REQUEST

Current Zoning: N1-A (neighborhood 1-A), RE-3(CD) (research, conditional), OFC (office), CG (general commercial), B-1(CD) (neighborhood business, conditional).
Proposed Zoning: UR-2(CD) (urban residential, conditional)

Approximately 33.03 acres located along the west side of John Adams Road, south side of Galloway Road, north of West Mallard Creek Church Road, and east of Interstate 85.

The petition proposes to develop a residential community containing a maximum of 345 single-family attached dwelling units in a townhouse style.

REZONING SITE PLAN

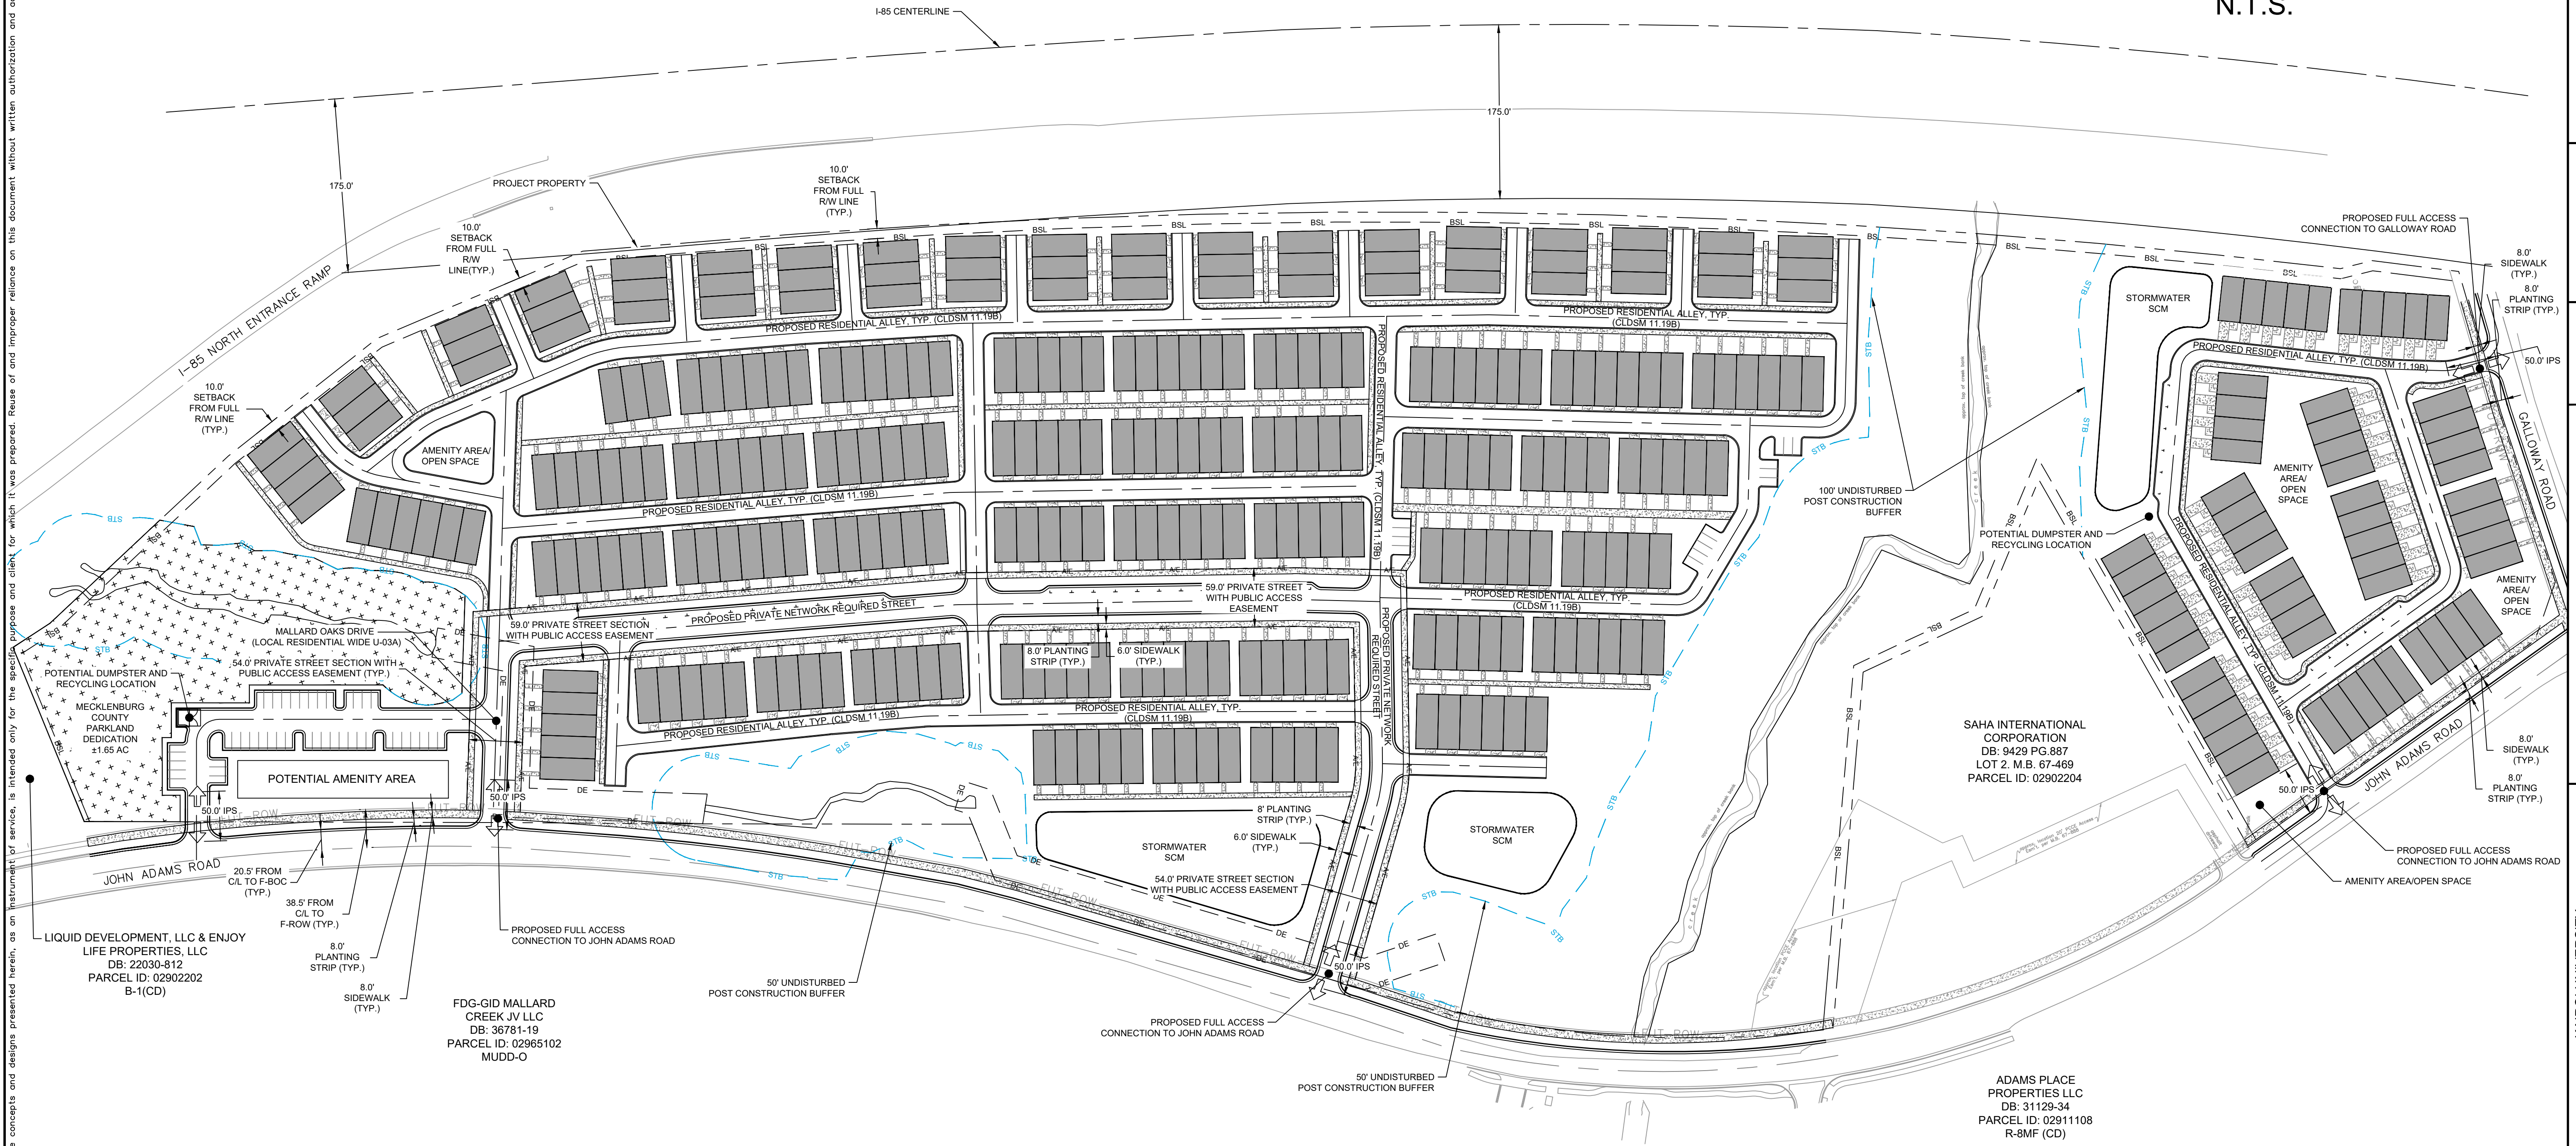
1. ~~Consider relocating amenity area to a more central location within the site.~~ Addressed
2. ~~Show visitor parking for the Galloway Road section of the development.~~ Addressed
3. ~~Show dumpster and recycling location for the Galloway Road Section of the development.~~ Addressed
4. ~~Consider connecting the John Adams portion of the site to the Galloway Road portion via a walking trail.~~ Addressed
5. ~~Consider breaking up the 6-unit buildings into 4-unit buildings.~~ Addressed
